DECISION DELEGATED TO HEAD OF PLANNING

Application No: H09-0377-23 **Applicant:** Mr & Mrs Taylor
Proposal: Erection of detached garage
Location: Woodhouse Farm Hurn Road Holbeach Hurn
Terminal Date: 15th June 2023

Title | Garage Drawing

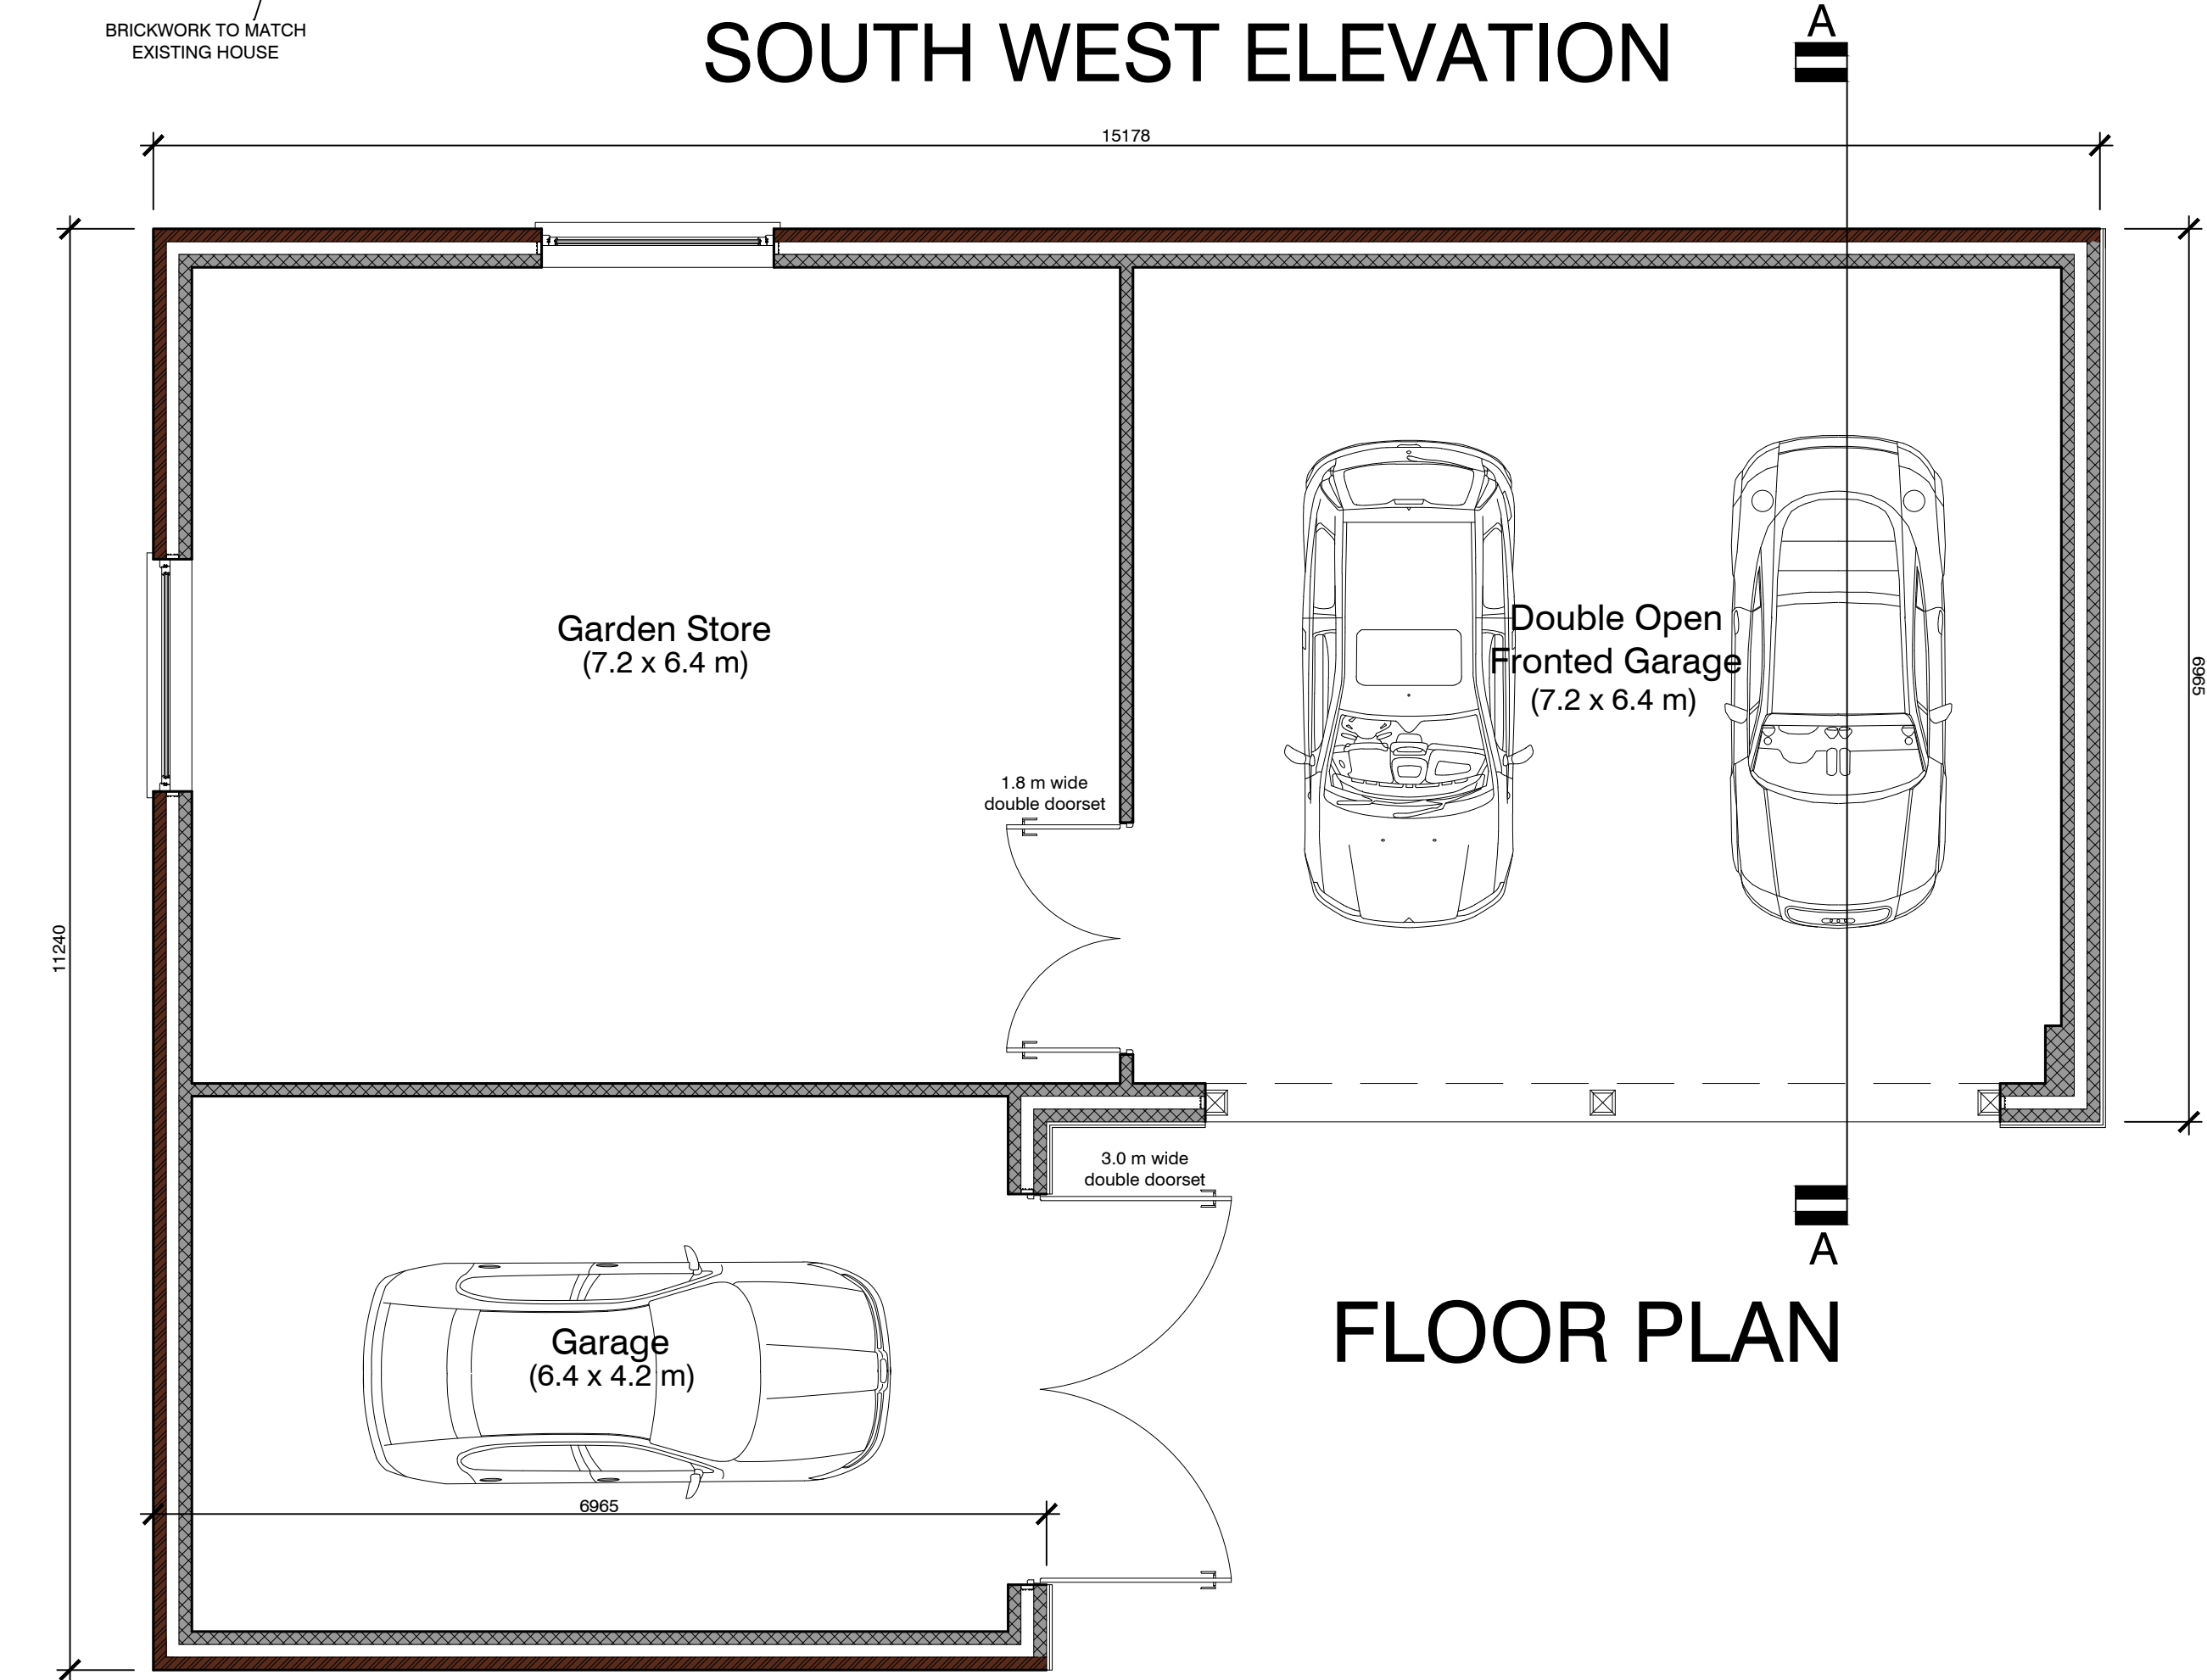
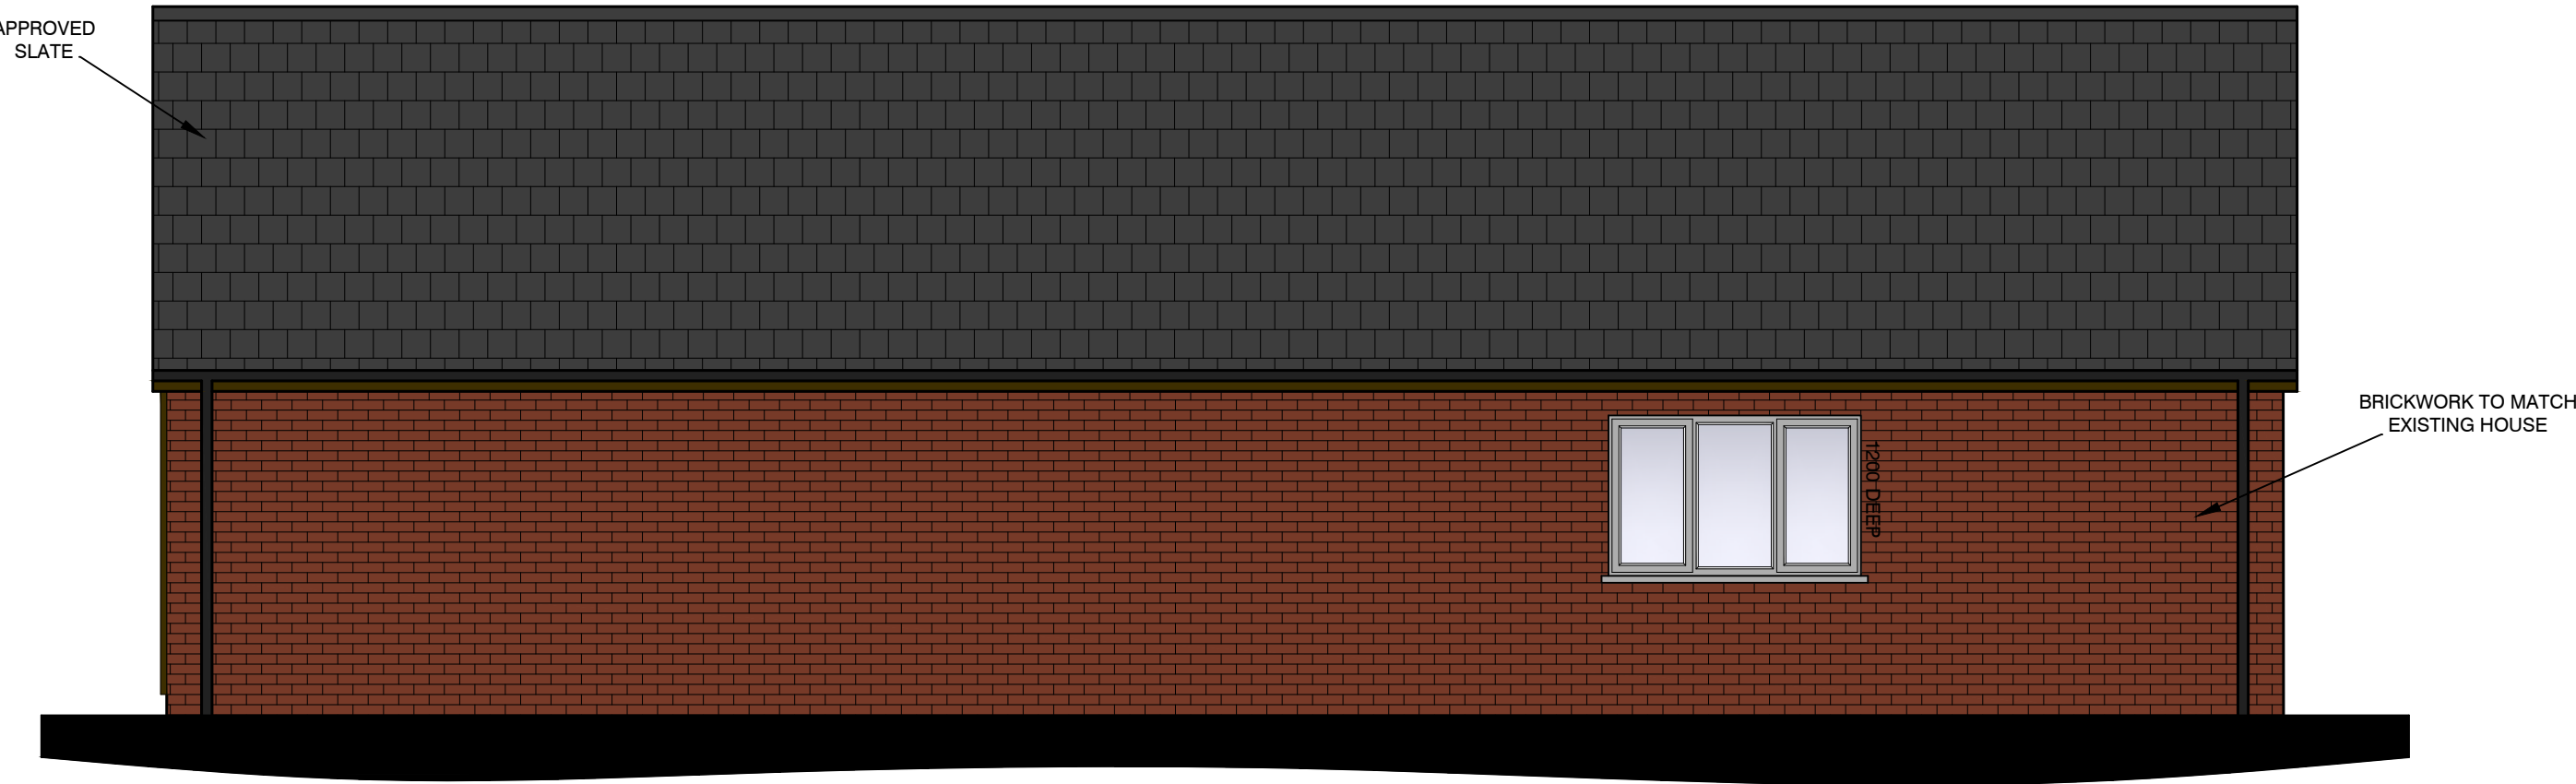
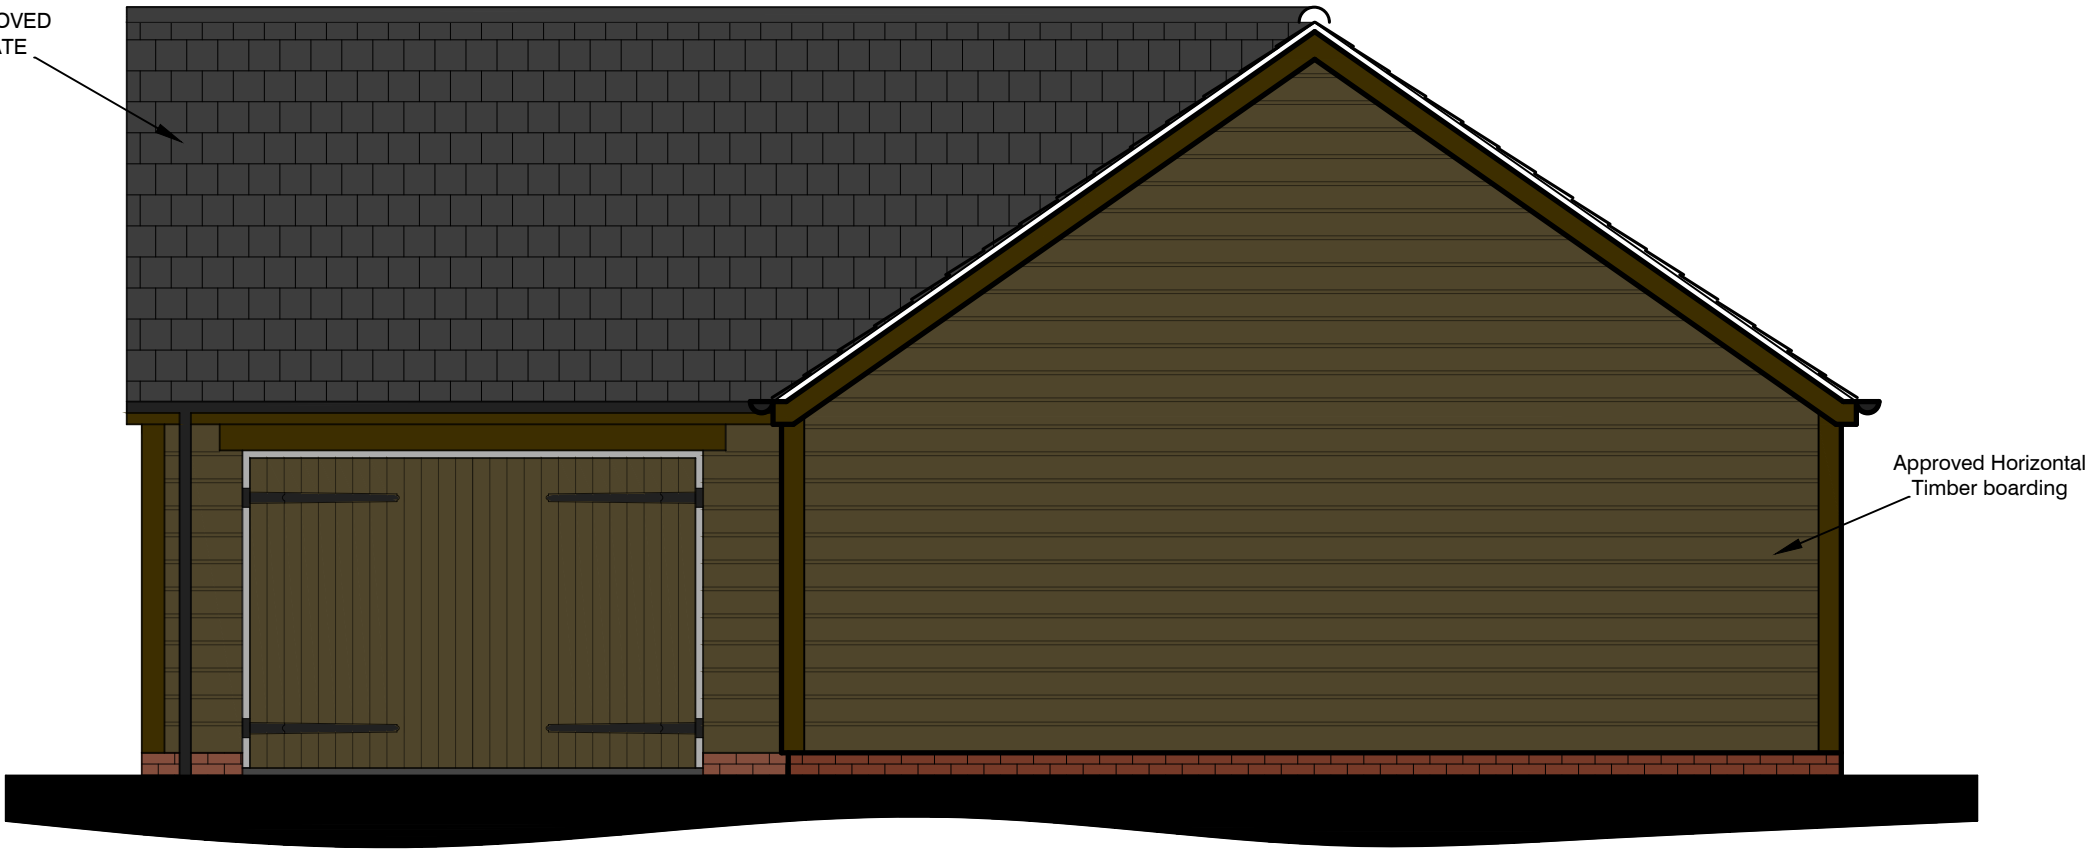
The proposed detached garage will be situated to the west of the existing house approximately 4.8 metres away. It will be split into three sections internally including a 'Garden Store' to allow for more storage for the applicants, this will have a floor area of 7.2m by 6.4m. Adjacent to this there will be a 'Double Open Fronted Garage' with a floor area of 7.2m by 6.4m and there will also be a 'Single Garage' with a floor area of 6.4m by 4.2m. The total floor area of the proposal is 121 metres squared. The dimensions of the proposal are 15178mm (length) at the rear of the garage, 11240mm (width), 6965mm (width) and 6965mm length for the single garage section.

The proposed design is in keeping with the existing dwelling on site as the brickwork has been selected to match that of the existing house and the slate is also of a similar design and colour. This ensures that the garage won't stand out or look out of place compared to the dwelling. As the existing dwelling and this proposed garage will be the only properties on the site it will also be in keeping with the locality of the area.

It can be considered that the overall size of the garage is very large and possibly not completely proportionate to the main house. However, the floor area is significantly smaller than the main house despite the length and width of the garage, the previous application on this site for a dwelling and a garage was approved with the total floor area of the garage being 126 metres squared for a 2 storey garage. This new garage is smaller in size when compared to what was originally approved. Therefore the dimensions and measurements are considered to be proportionate to the dwelling and it complies with Policies 2 & 3 of the SELLP and Section 12 of the NPPF.
